Application by Highways England for an Order Granting Development Consent for A57 Link Roads

Deadline 8 - response on behalf of High Peak Borough Council

Responses from High Peak Borough Council are provided in red to outstanding matters discussed in the hearing session held during the week commencing 4th April 2022.

Drawing Number	HE551473 - BBA - EGN - A57_AL_SCHEME - DR - LE - 060414
Location	Location
Scale	1:5,000
Original Size	A3
Rev	P01

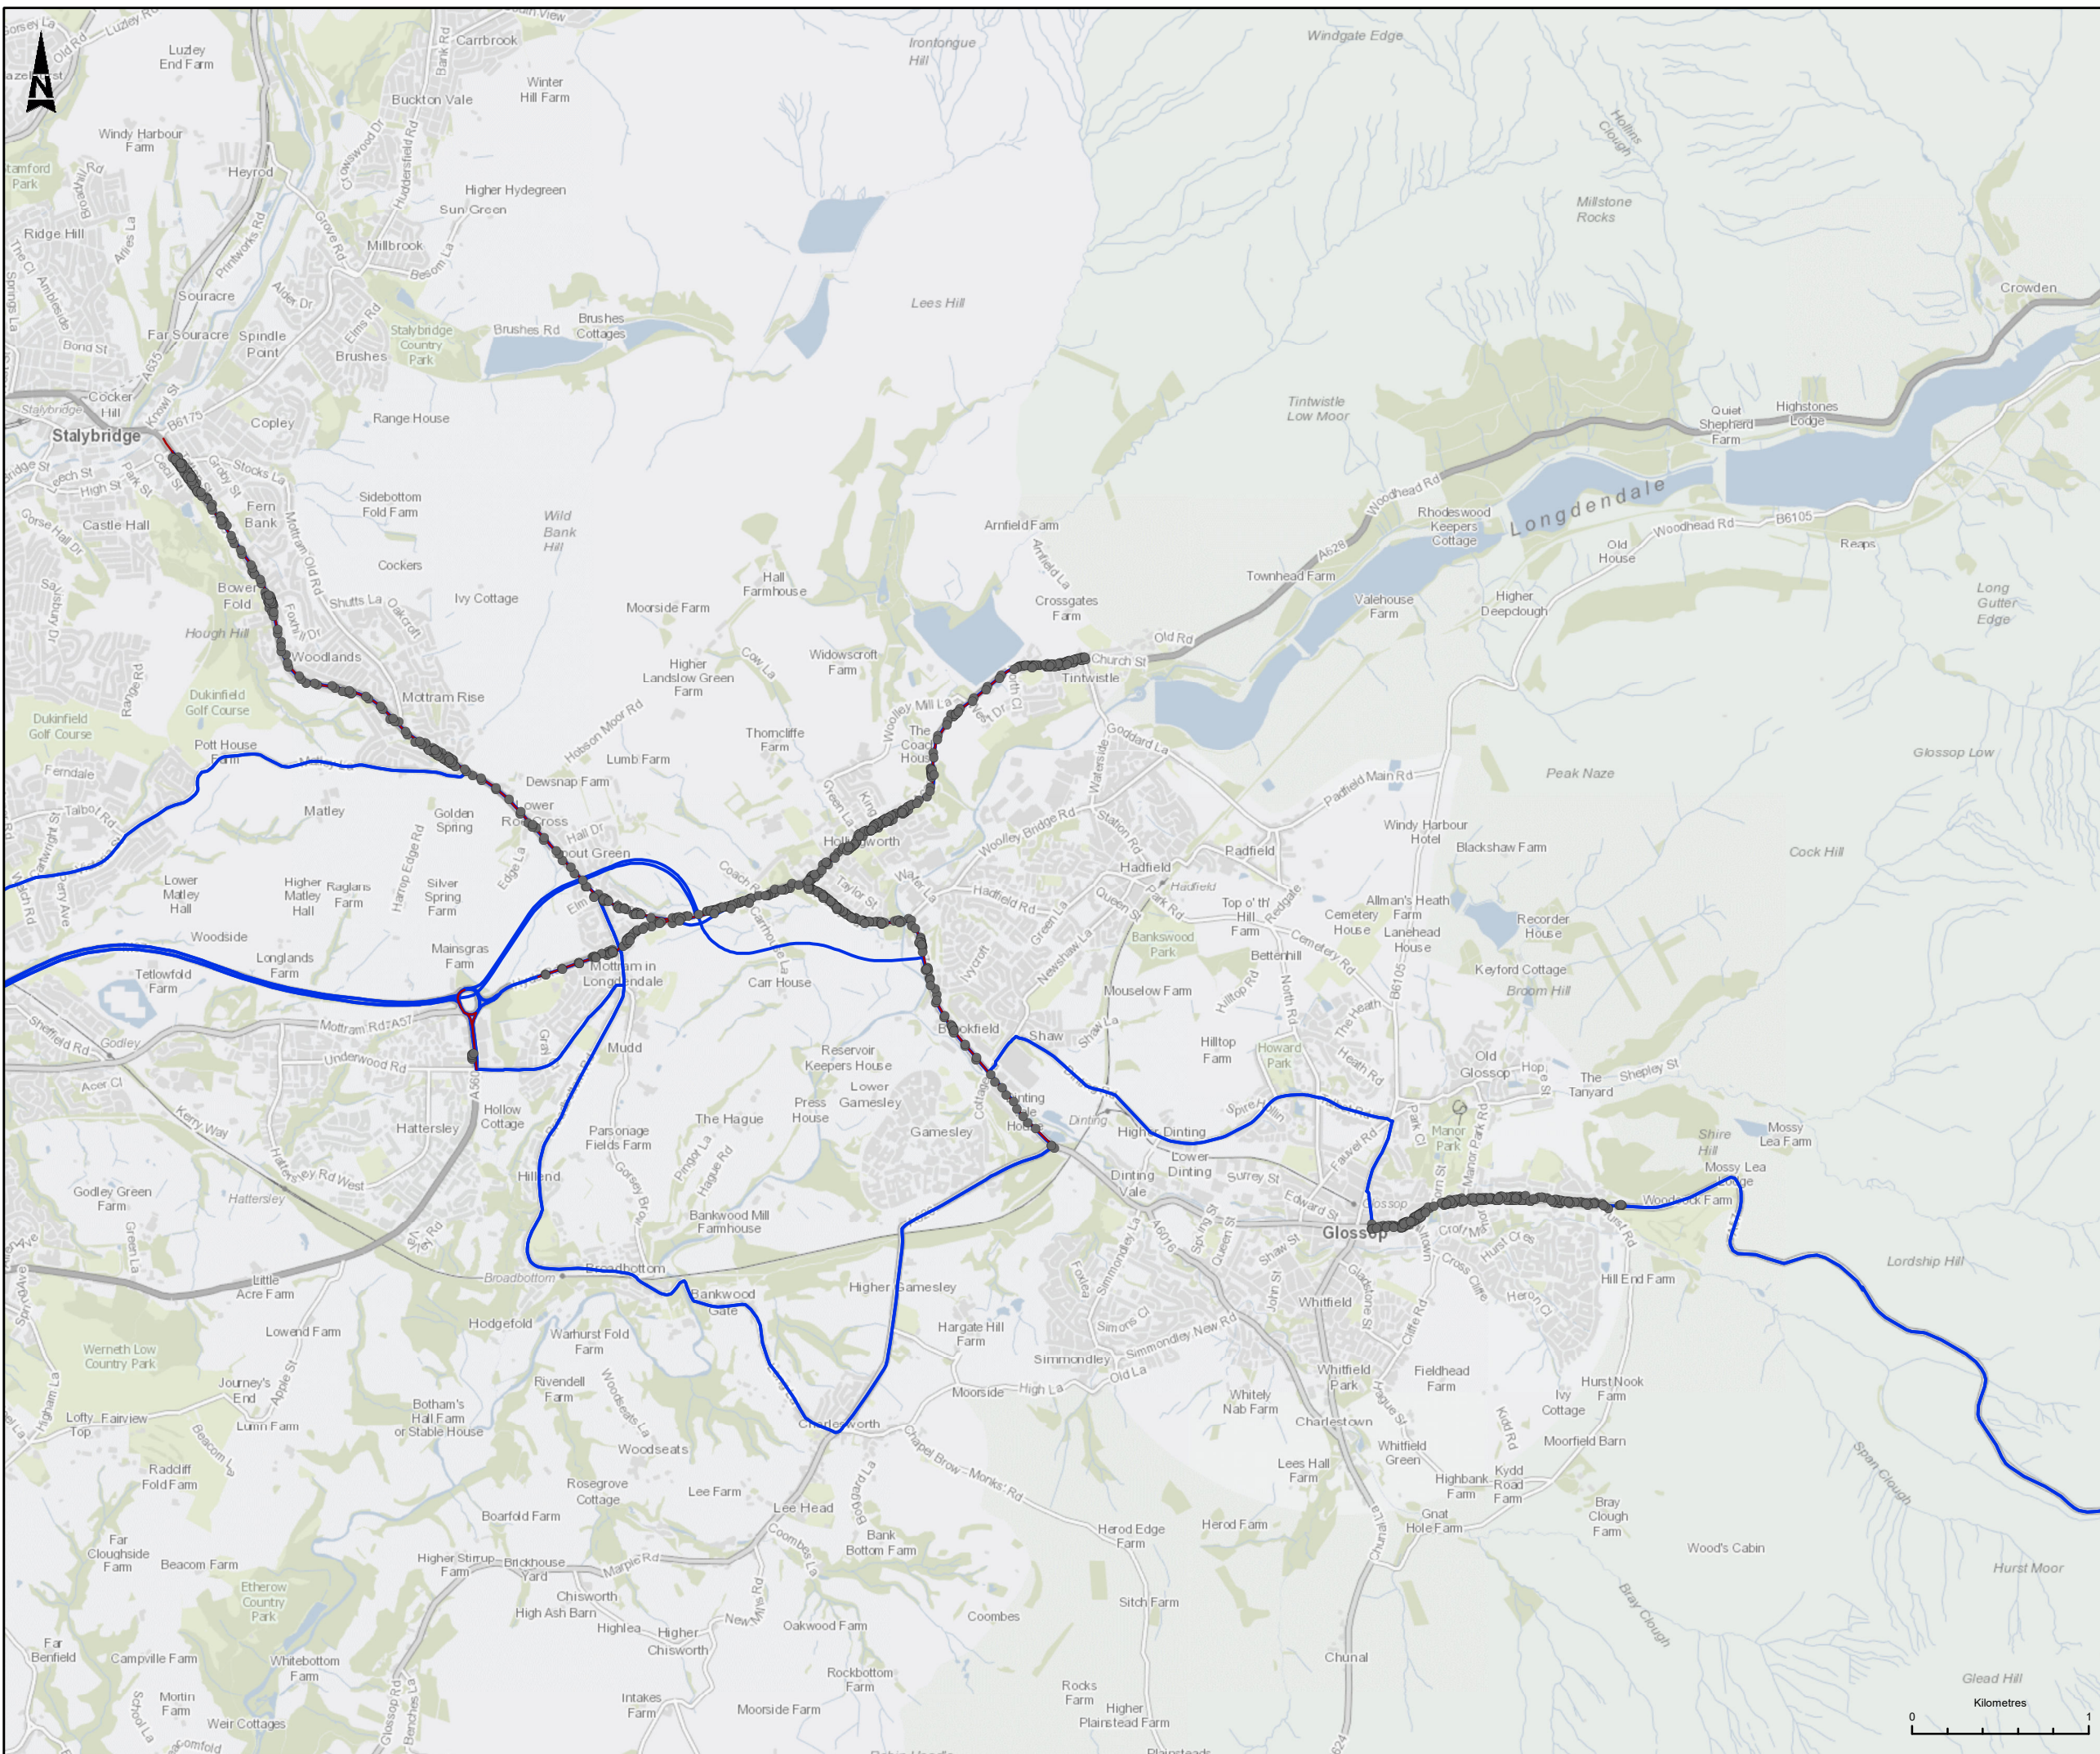
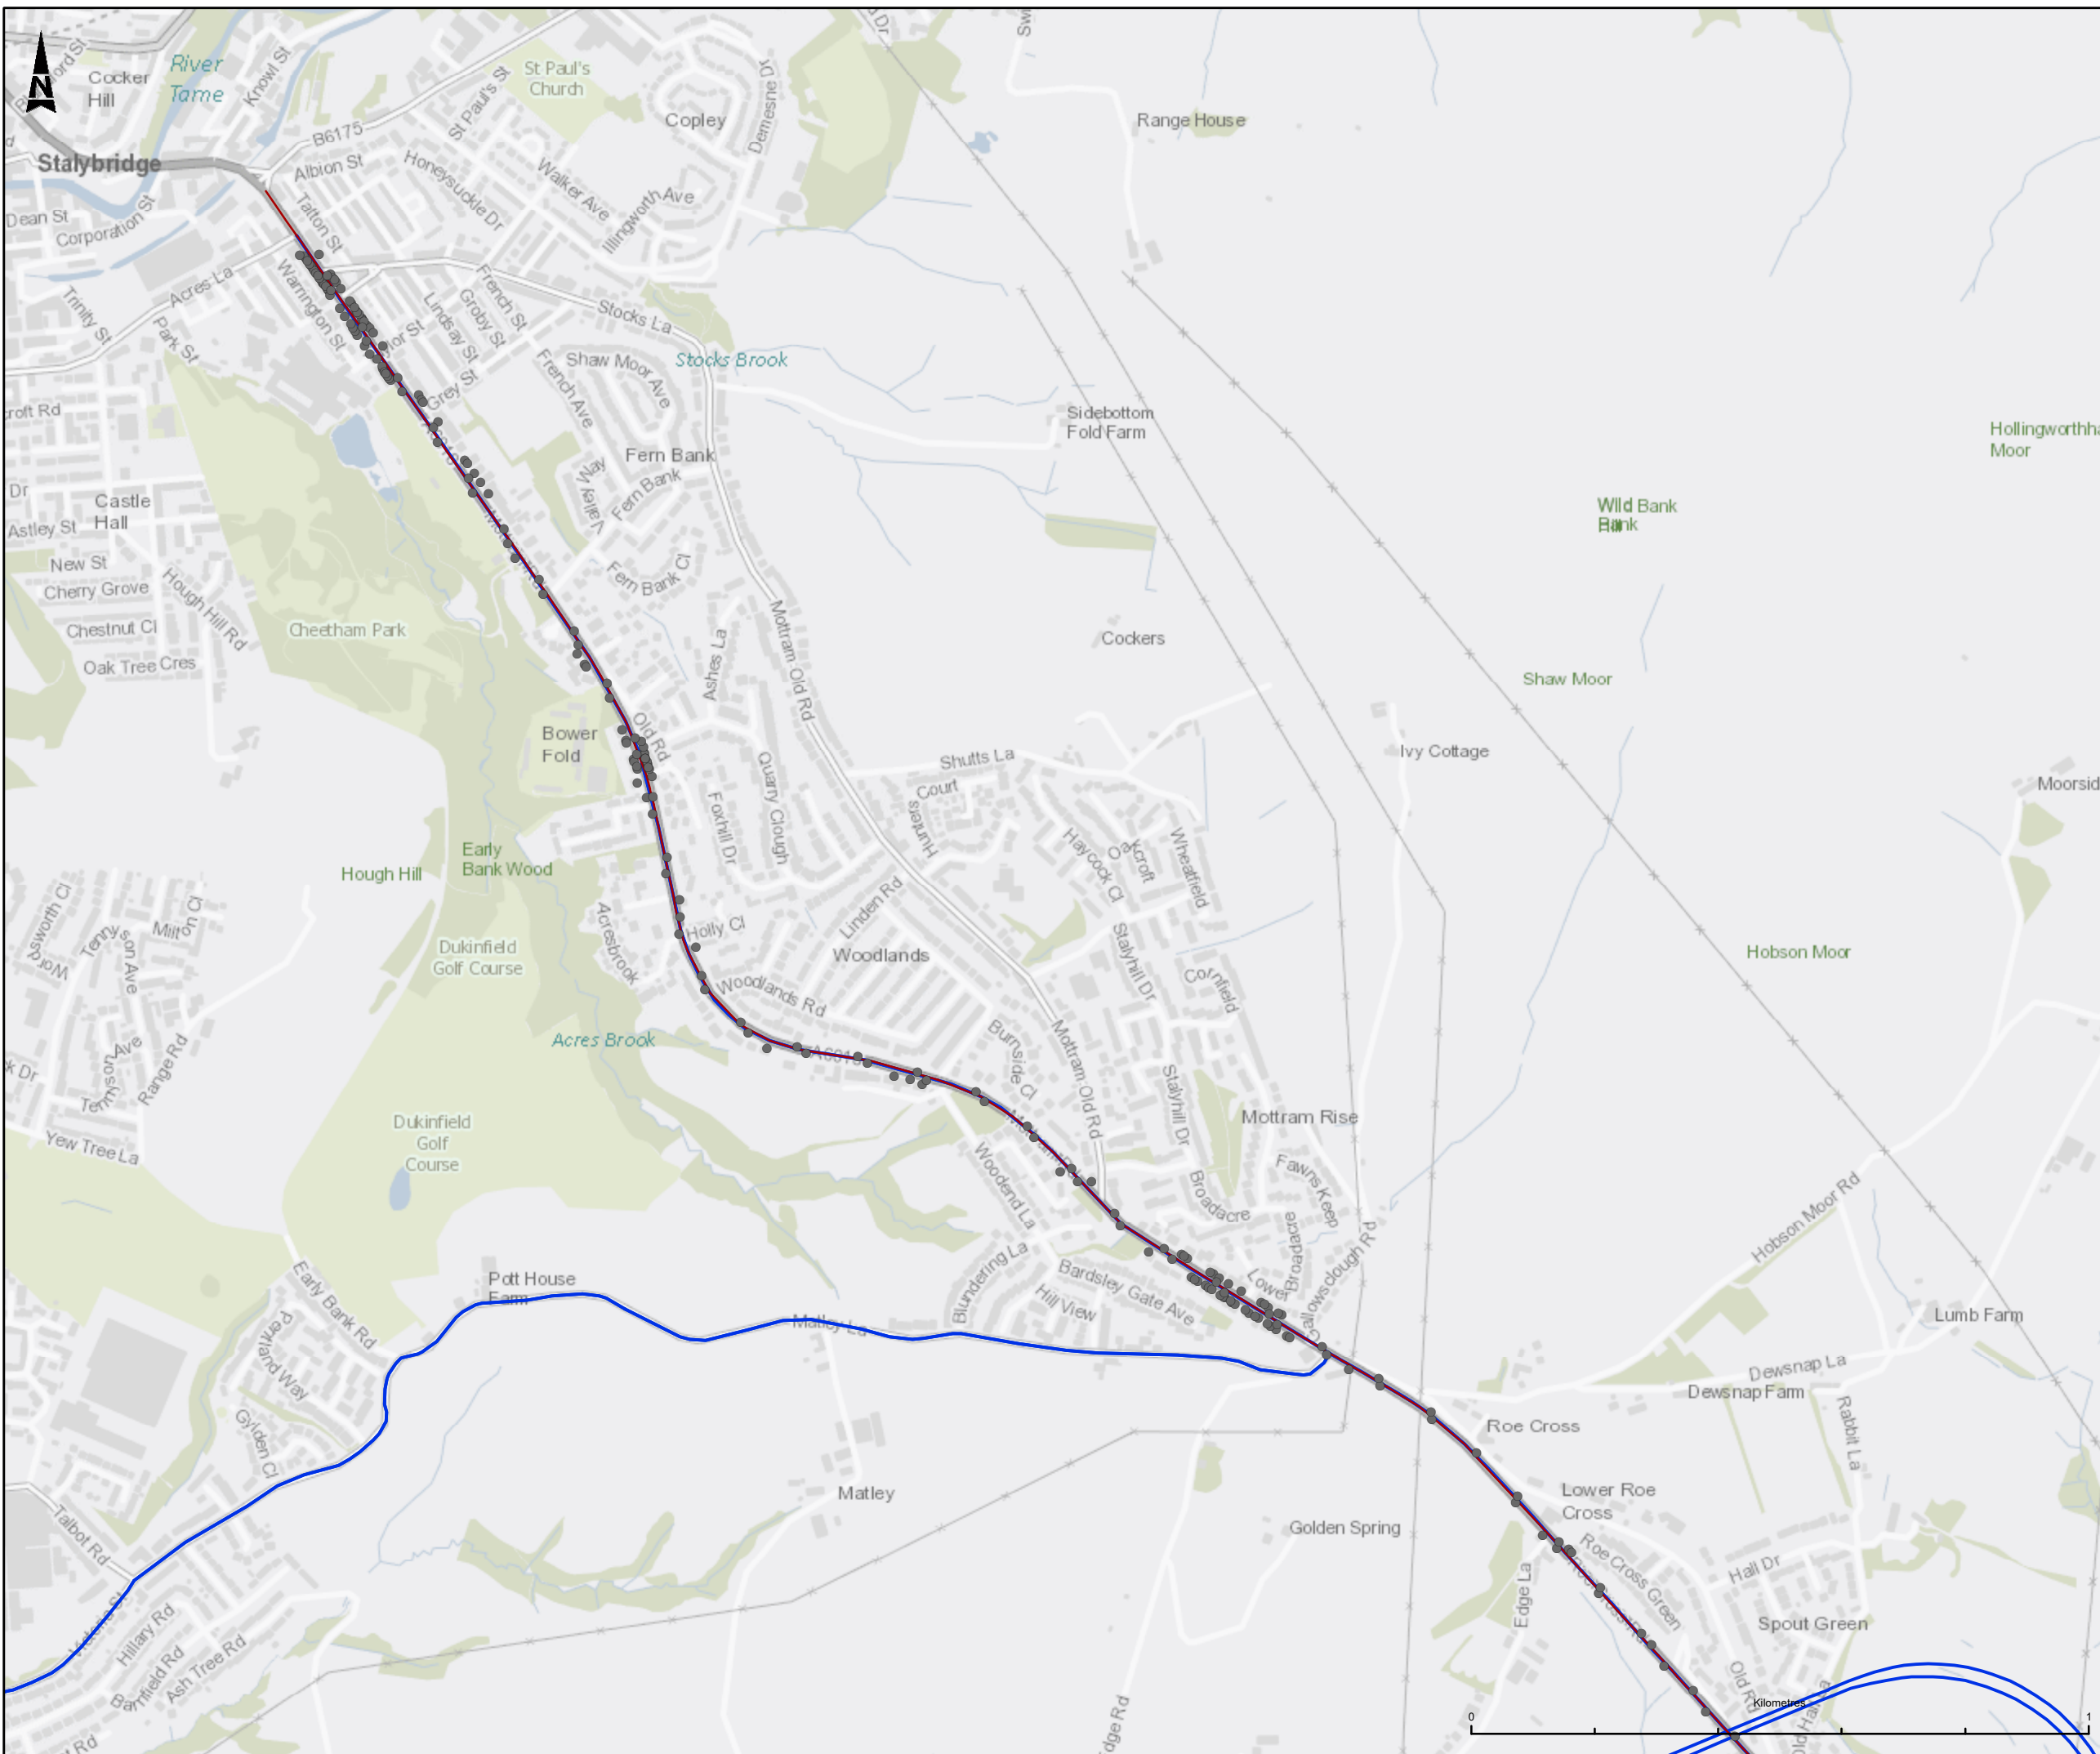
<u>Figure 5.4 Air Quality Compliance Risk Assessment – receptor labels</u>			
<p><u>Item 8.38</u> HPBC [REP4-011] asked for the A57 Brookfield qualifying features used in the NO2 compliance assessment to be</p>	<p>Given the number of qualifying features and public access receptors included in the compliance assessment it was not possible to practically label the qualifying features in ES Figure 5.4 (APP-080) however,</p>	<p>Agreed Deadline 8 update (HPBC) It is noted that this response was supplied at deadline 7 by NH. Clarification of receptors</p>	<p>Closed</p>

HPBC Item	National Highways Position	HPBC Position	Status
	<p>traffic scoping criteria requiring further assessment.</p> <p>The temporary traffic management measures will generally be short term, with the arrangements, timing and phasing being designed to minimise traffic congestion and delay far as reasonably practicable. Inevitably, however, some of the temporary traffic management arrangements are likely to cause some additional short term traffic congestion and delay within the immediate vicinity of the Scheme, but this is not anticipated to be sufficient to result in any material change in traffic flows or congestion on roads within HPBC.</p> <p>The approach to the assessment of the impact of construction traffic management has been further discussed and agreed with HPBC (virtual meeting held 4th March 2022).</p>		
<u>Human health receptors A57 Brookfield</u>			
<p><u>ISH 3 Item 5 Air Quality Question j</u></p> <p>Within the response to question j, HPBC raised a concern regarding the</p>	<p>Following further discussion and clarification with HPBC (virtual meeting held 8th April 2022) it has been agreed that a sensitivity test will be undertaken to identify the air quality impact at relevant qualifying</p>	<p>Deadline 8 update (HPBC) Further to Item 8.38; Identification of the receptors (figure 5.4) used in the compliance risk assessment</p>	<p>Open</p>

HPBC Item	National Highways Position	HPBC Position	Status
<p>magnitude of change reported in the compliance risk assessment at qualifying feature receptors adjacent to the A57 Brookfield.</p>	<p>feature receptors located adjacent to the A57 Brookfield under the DMRB LA 105 human health assessment methodology.</p>	<p>(using LAQM “conservative” forecast”) indicated that “large” change at some of the receptors along Brookfield. However, it also highlighted that some of these were human health receptors that had not been included as receptors in the (less conservative) primary human health AQ assessment (DMRB LA 105). Therefore, HPBC have requested that these receptors are also assessed in accordance with the DMRB LA 105</p>

HPBC Item	National Highways Position	HPBC Position	Status
labelled on ES Figure 5.4 [APP-080].	an extract of ES Figure 5.4 zoomed in on the A57 Brookfield area with receptor ID labels for qualifying features and public access receptors adjacent to the A57 Brookfield is provided below this table.	did highlight that there were some relevant receptors in the Brookfield area that had not been included in general AQ assessment but had been included in the compliance assessment (see final row)	
<u>Adjustment of Background Concentrations Data used in Air Quality Assessment</u>			
<p><u>Item 8.39</u></p> <p>HPBC raised concerns about the lack of adjustment to the background concentrations used in the air quality assessment. HPBC [REP4-011] suggest they are concerned about over representation of beneficial effects.</p>	<p>The HPBC query relates to the verification and adjustment of the Department for Environment, Food and Rural Affairs (Defra) mapped background concentrations. National Highways provided a response to question 8.39 in REP3-018. As stated in REP3-018, where the Defra background maps underpredict background monitoring data this could lead to a need to apply a higher adjustment factor in the air quality model verification. The higher the adjustment factor applied, the more conservative the results of the assessment given that the adjustment is applied to both the modelled total concentration with and without the Scheme, which has the effect of increasing the change in concentration. Where concentrations</p>	Agreed	Closed
